State of Washington  
DEPARTMENT OF FISH AND WILDLIFE  
South Central Region • Region 3 • 1701 South 24<sup>th</sup> Avenue, Yakima, WA 98902-5720  
Telephone: (509) 575-2740 • Fax: (509) 575-2474

RE: VA-16-00001 Mostofi Setback Variance

VA-16-00001

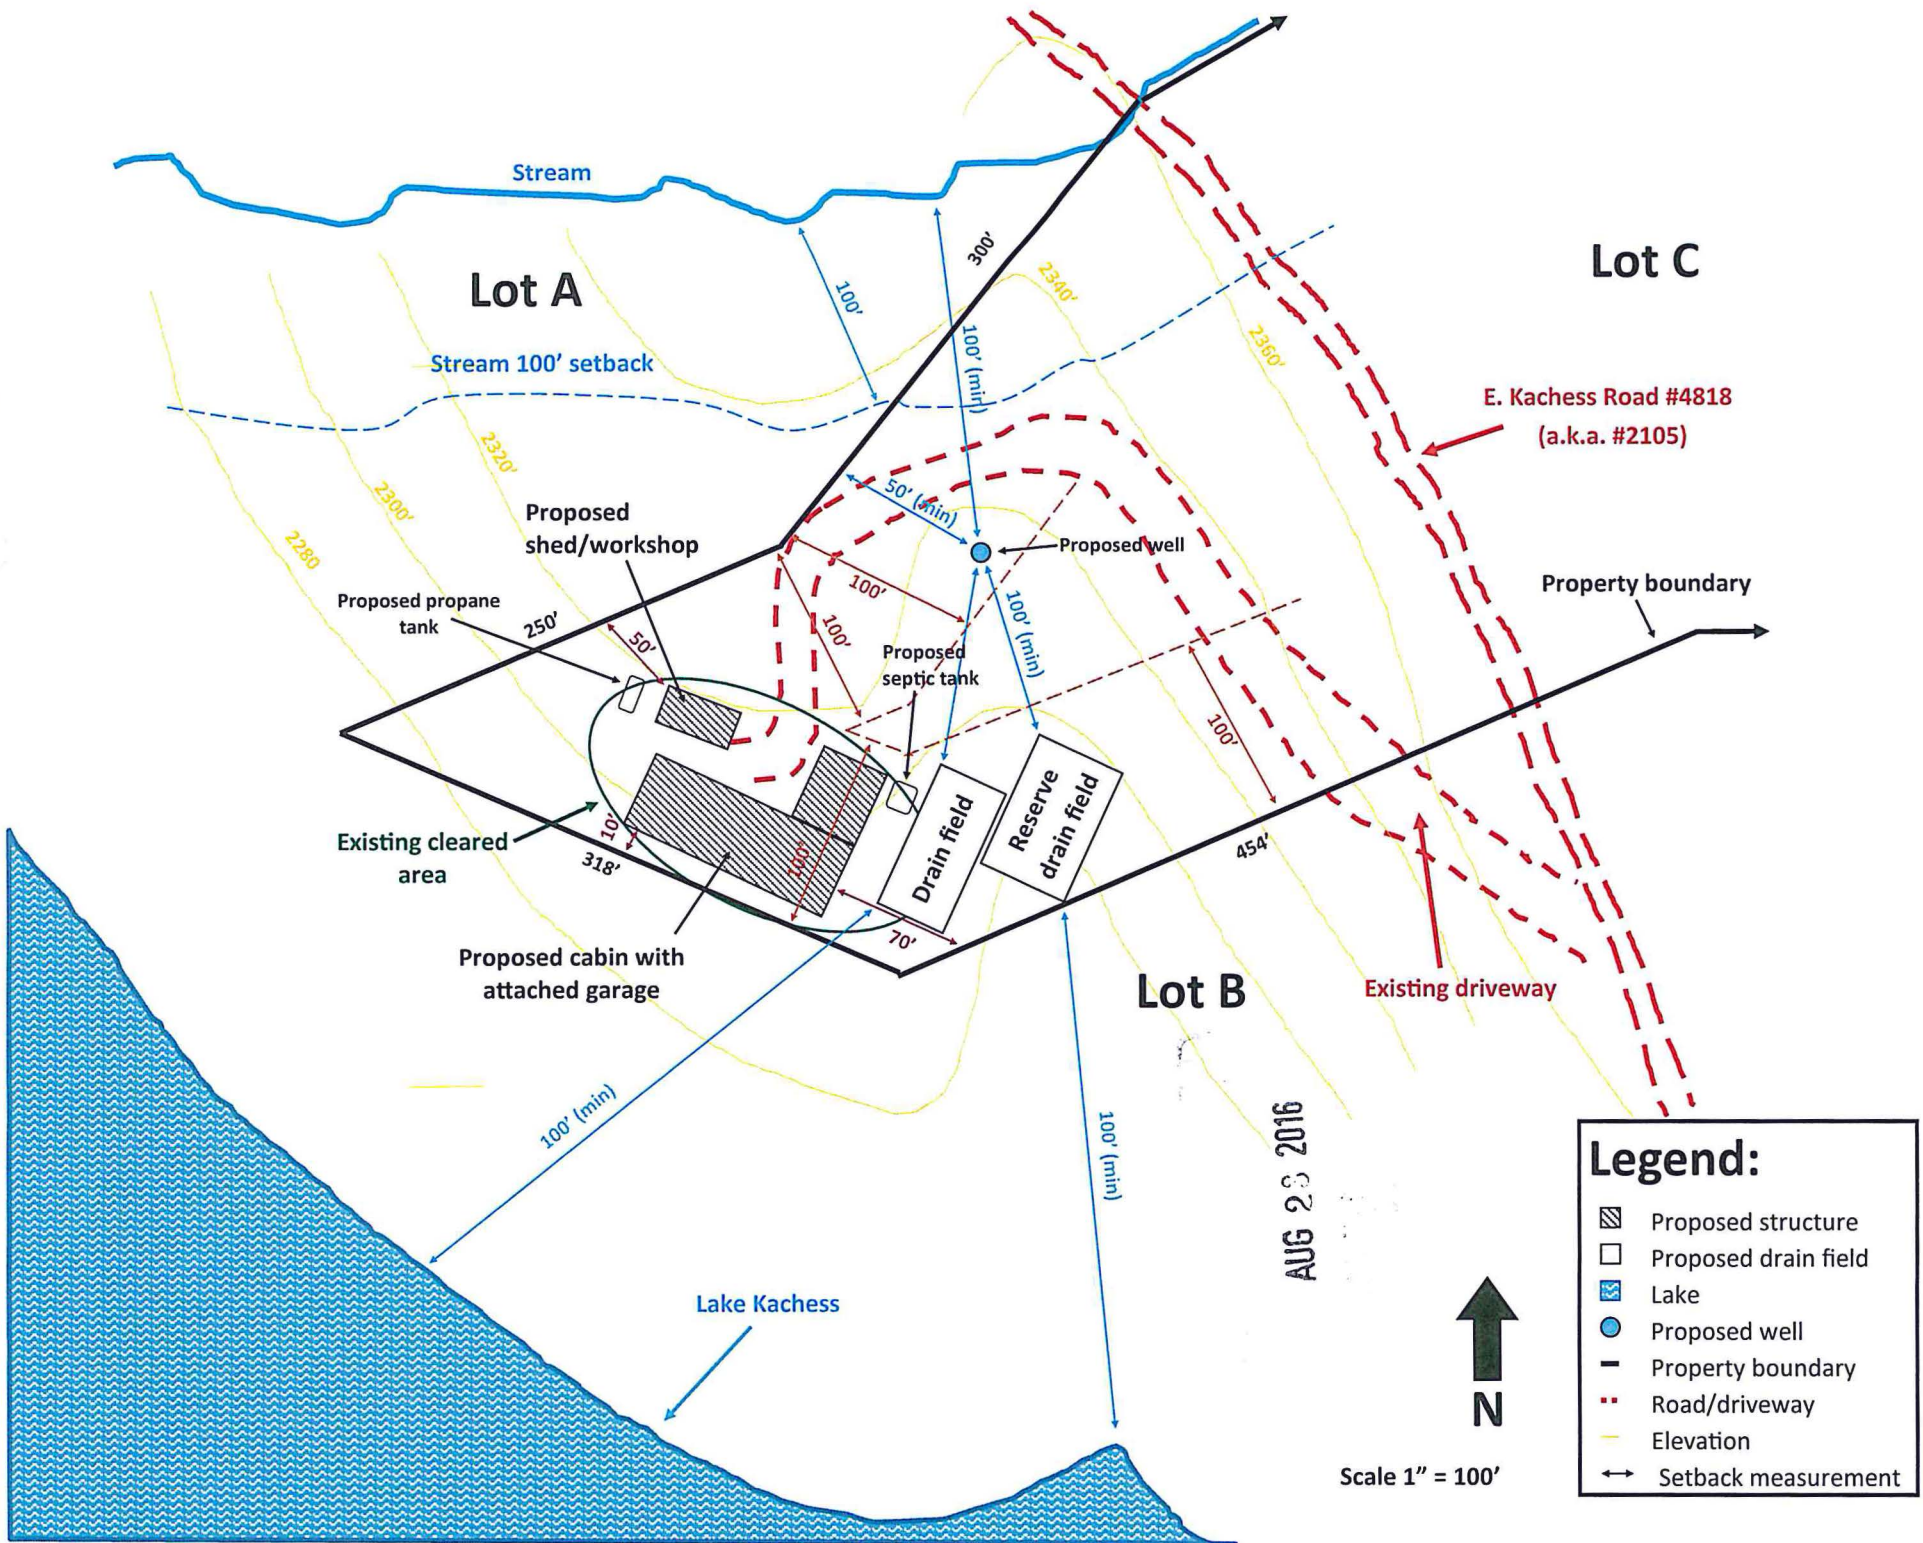
Thank you for the opportunity to comment on this variance request. The Washington Department of Fish and Wildlife (WDFW) has reviewed the variance request application and supporting documents. The subject land is located along East Kachess Road along the eastern shore of Lake Kachess. The applicant is looking to develop the lot that is near to the Lake Kachess shoreline and the perennial stream that is located to the north of the parcel.

Within the area proposed for building, the perennial stream to the north of the building site is fish bearing and given its close proximity to Lake Kachess could have potential for use by a variety of fish species, including Bull Trout, a listed species. Thus, WDFW requests that the 100 foot minimum buffer for the stream and the shoreline be left in place. These are the main concerns that WDFW has with this variance.
